COUNTY COUNCIL'S RESPONSE TO CONSULTATION ON THE FOLLOWING DEVELOPMENT PROPOSAL

Application no: 24/02058/F

Proposal: Full application for the proposed erection of a two storey building to form a 66 no. bedroom care home for older people with parking, access, landscaping and associated ground works.

Location: Land to the North of Anniversary Avenue, Graven Hill , Bicester, OX25 2BF

TITLE
Drainage Strategy

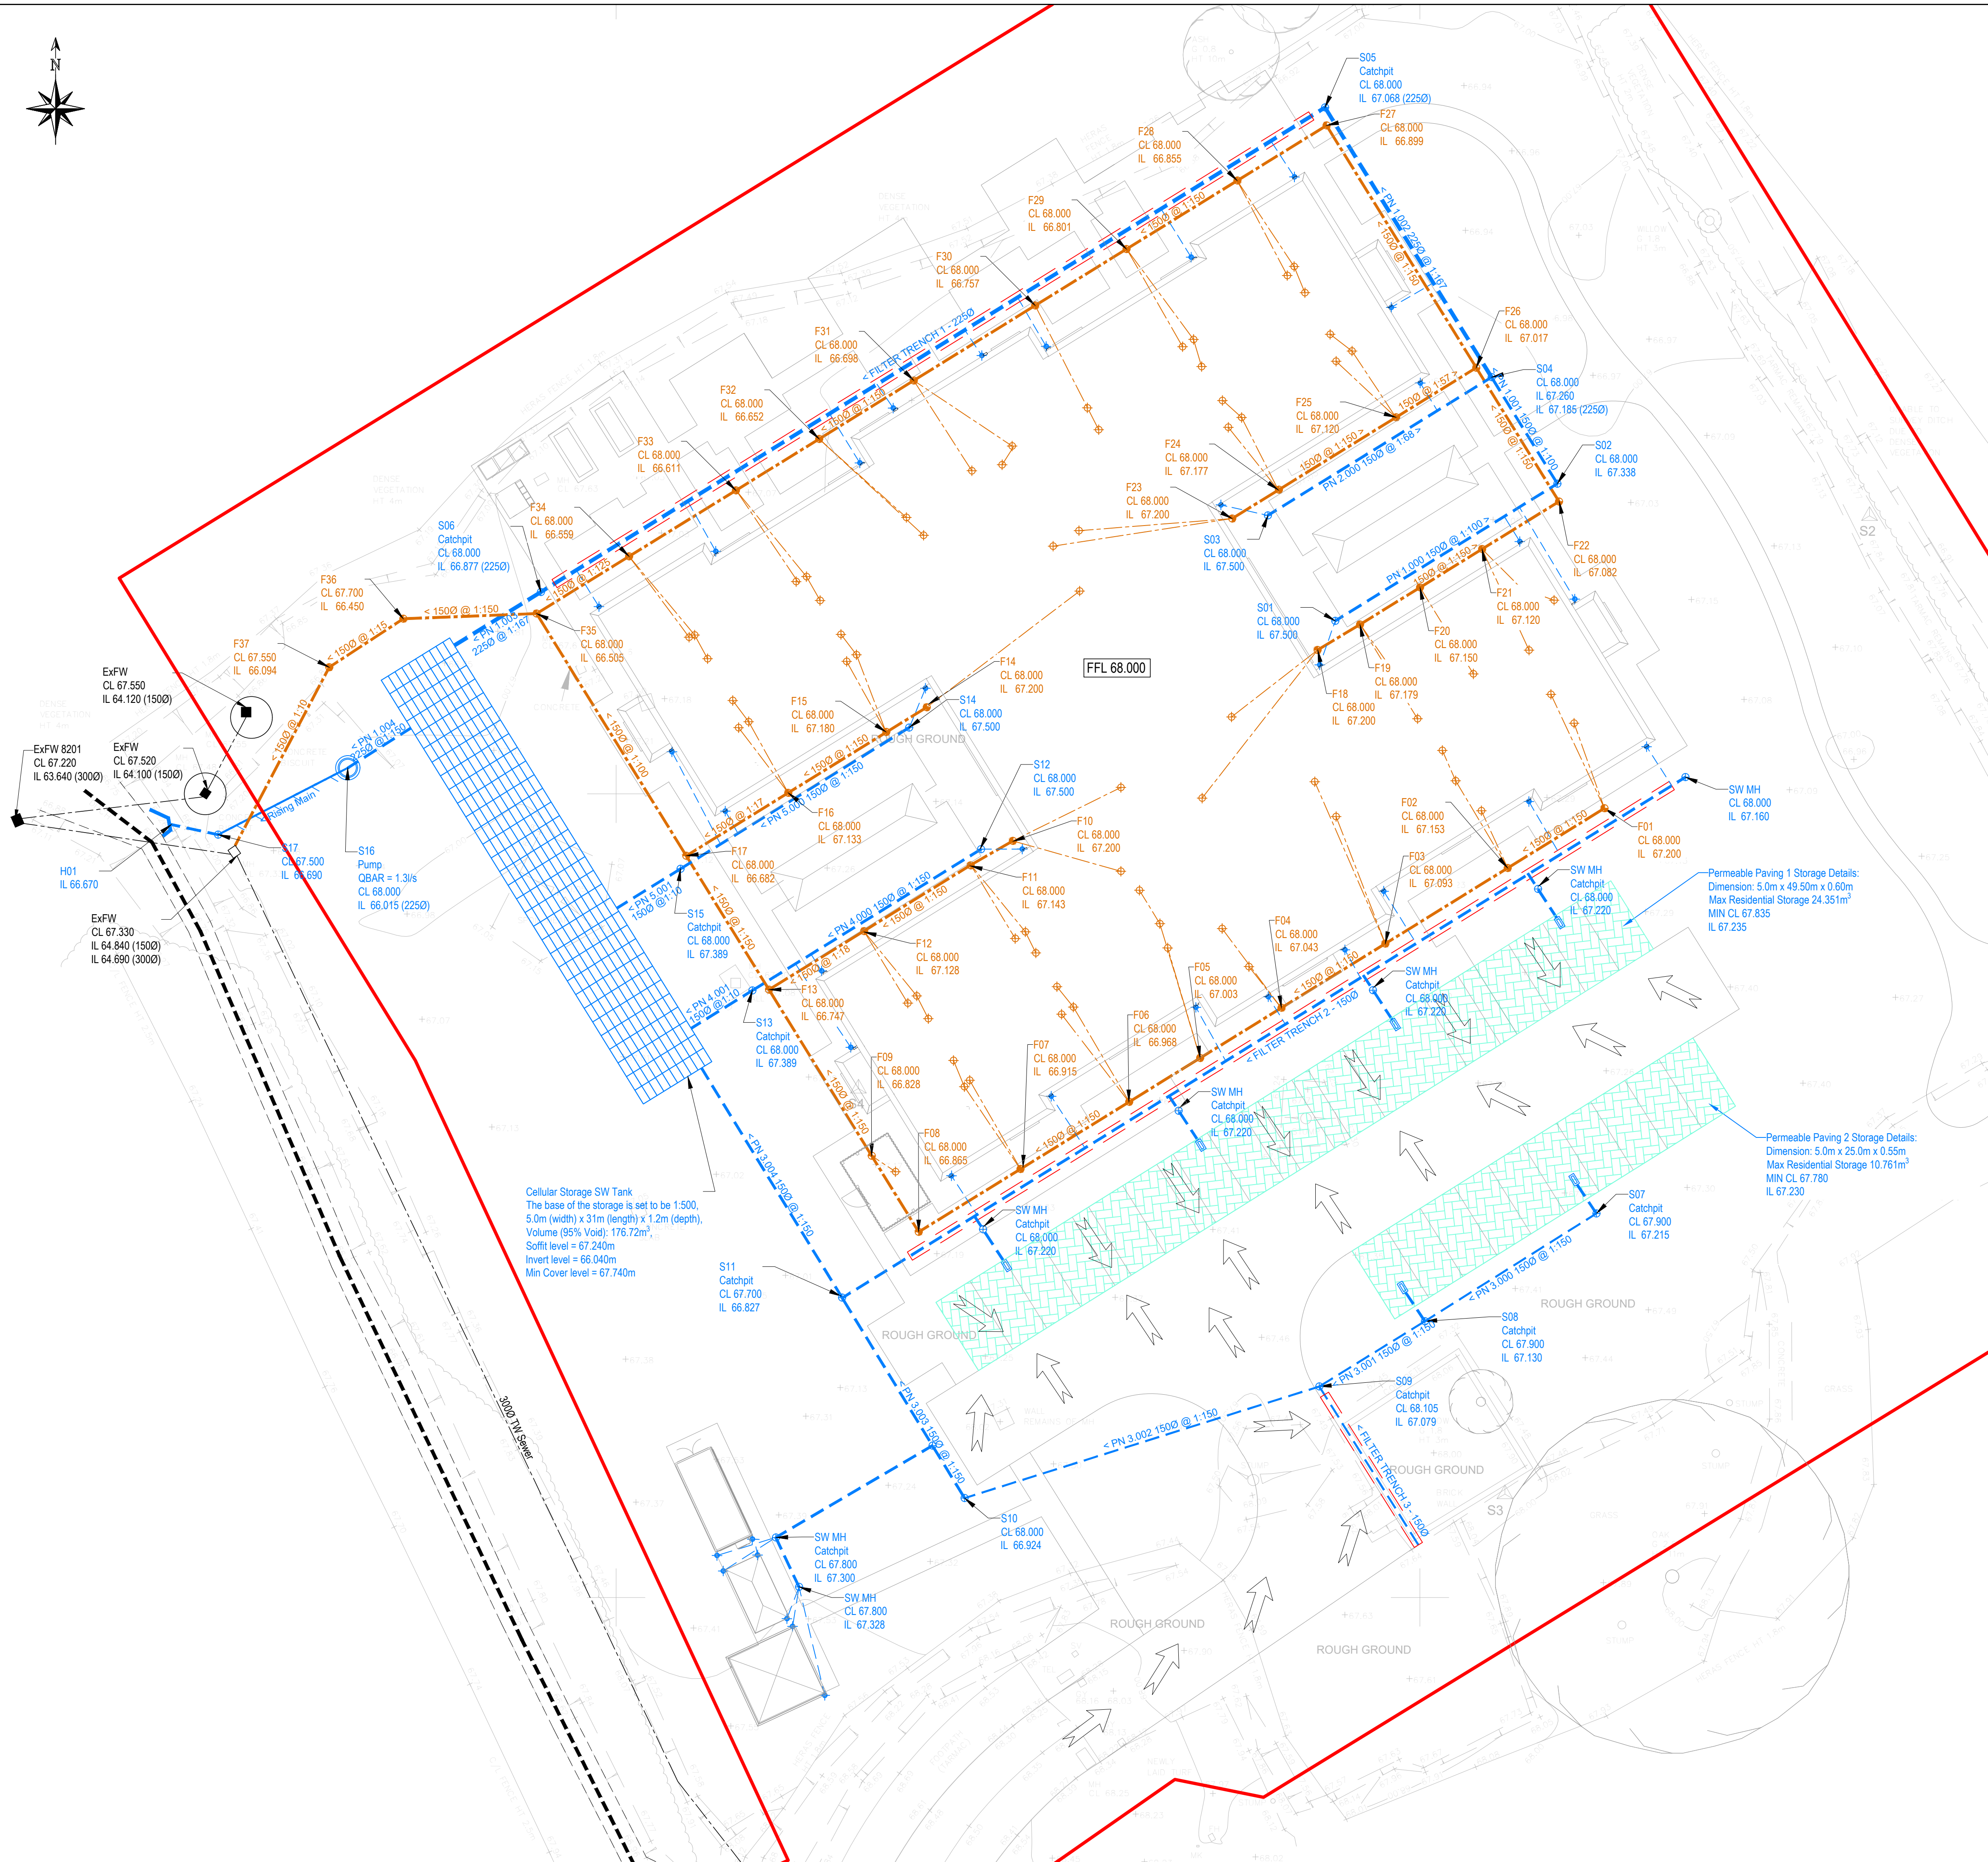
The flow control device restricting the discharge from the site has been revised so that there is a single discharge rate equivalent to Q_{bar} . This is still a pumped discharge, however is a much simpler solution that should ensure that the discharge rate for each storm event cannot be exceeded up to the design storm event. The conditions below are proposed to accommodate any further detailed design changes and additional maintenance information.

Construction shall not begin until a detailed surface water drainage scheme for the site, has been submitted to and approved in writing by the Local Planning Authority. The scheme shall be subsequently be implemented in accordance with the approved details before the development is completed. The scheme shall include:

- A compliance report to demonstrate how the scheme complies with the “Local Standards and Guidance for Surface Water Drainage on Major Development in Oxfordshire”;
- Full drainage calculations for all events up to and including the 1 in 100 year plus 40% climate change;
- A Flood Exceedance Conveyance Plan;
- Detailed design drainage layout drawings of the SuDS proposals including cross-section details;
- Detailed maintenance management plan in accordance with Section 32 of CIRIA C753 including maintenance schedules for each drainage element, and;
- Details of how water quality will be managed during construction and post development in perpetuity;
- Confirmation of any outfall details.
- Consent for any connections into third party drainage systems
